Your Ref: OWPC24015
Our Ref: FP/139/19/OUT 23-06-2019
Please ask for:
Maria Tomalova

Outline application with all matters reserved for the erection of 1 No. dwelling.
Land south of garage compound & East of 12 Alfriston Close Felpham

Thank you for your internet representation made on 12th August 2019 which has been recorded as '**an objection**' with the comments as follows:

Land East of 12, Alfriston Close, Felpham, West Sussex, PO22 6QB

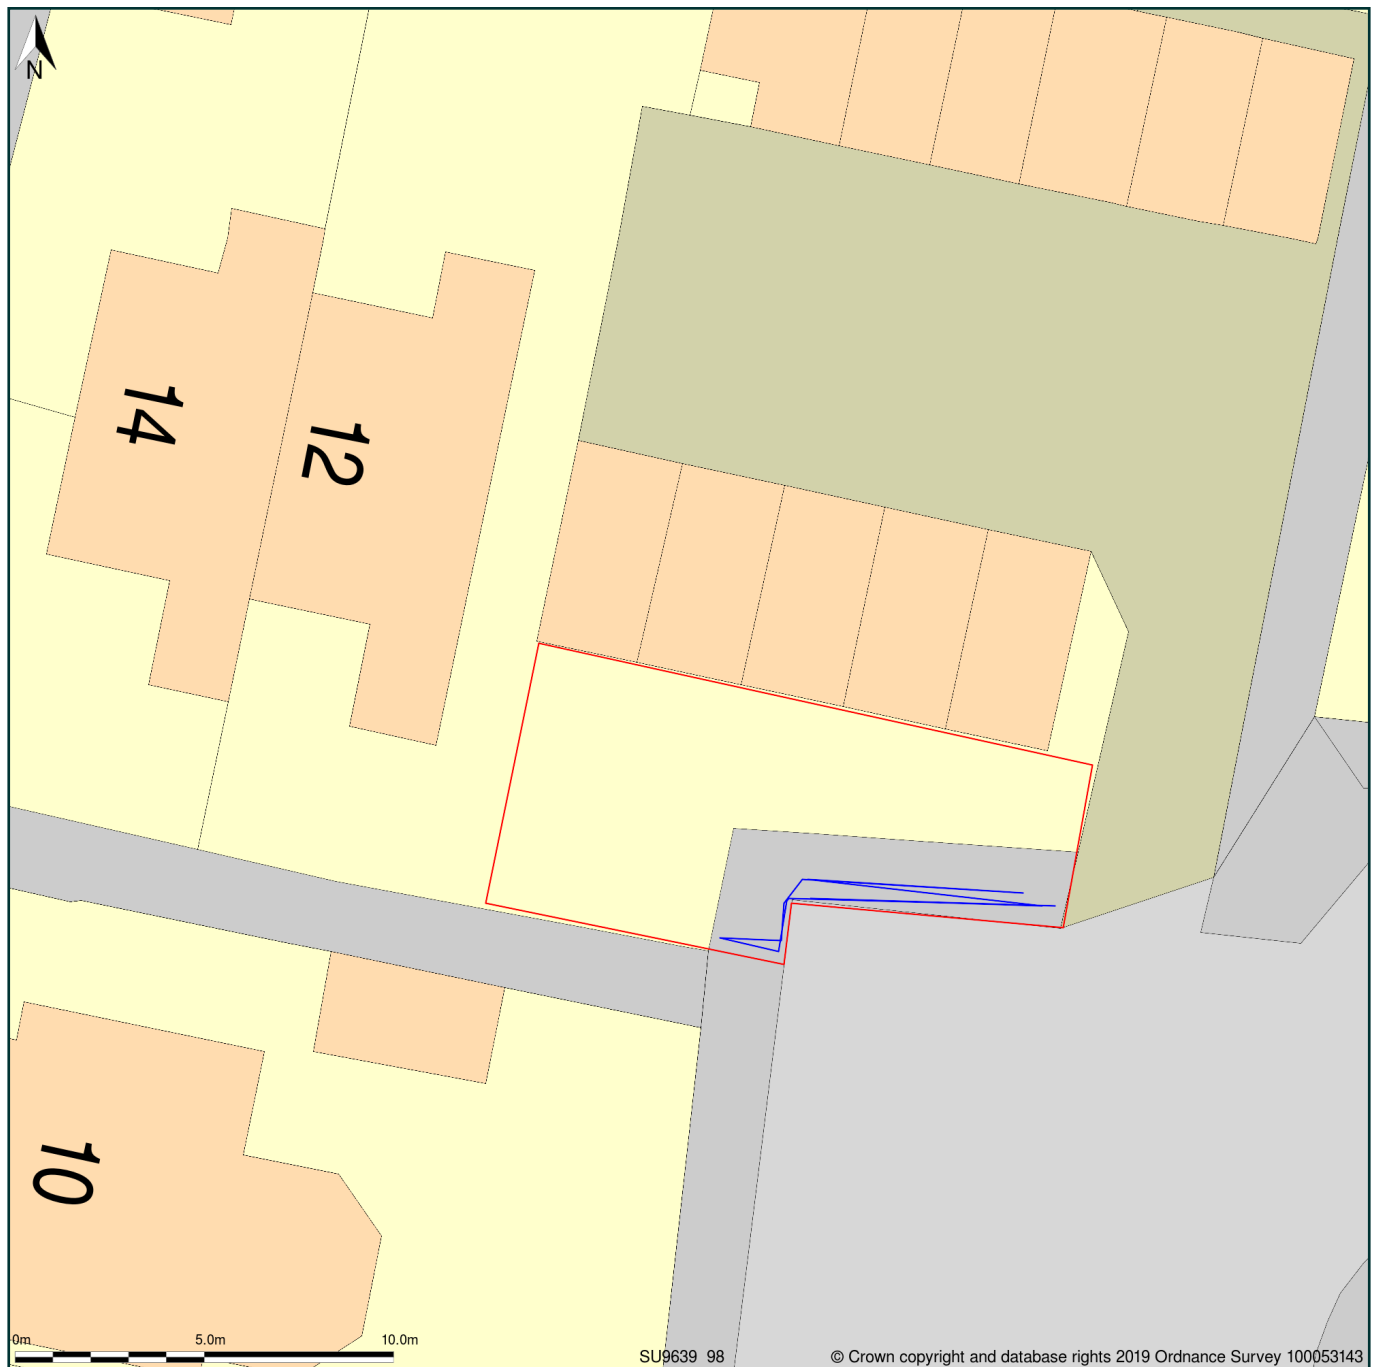
The agent refers to my comment that parking would be unaffected. It is plainly obvious that a rundown automatically removes parking for at least one car. Where the rundown is to be situated, access to parking on the property requires a minimum space of 2.4 metres by 4.8 metres, there appears to be only one space available to fit this without moving a tree which she says will not be affected. There is no mention from the agent about access to the backs of the garages for the owners but plenty about the roofs. Although the agent has singled me out about the parking issues I would like to point out that the parking issues have been raised in the majority of the other objections. I can only give my observations about this site as opposed to the agent with having 39 years of looking at this proposed site daily, the human equivalent of Google earth, updated daily, as to someone viewing by means of a desktop study or block plan. A site visit by someone to see the ridiculous application for a dwelling here is necessary.
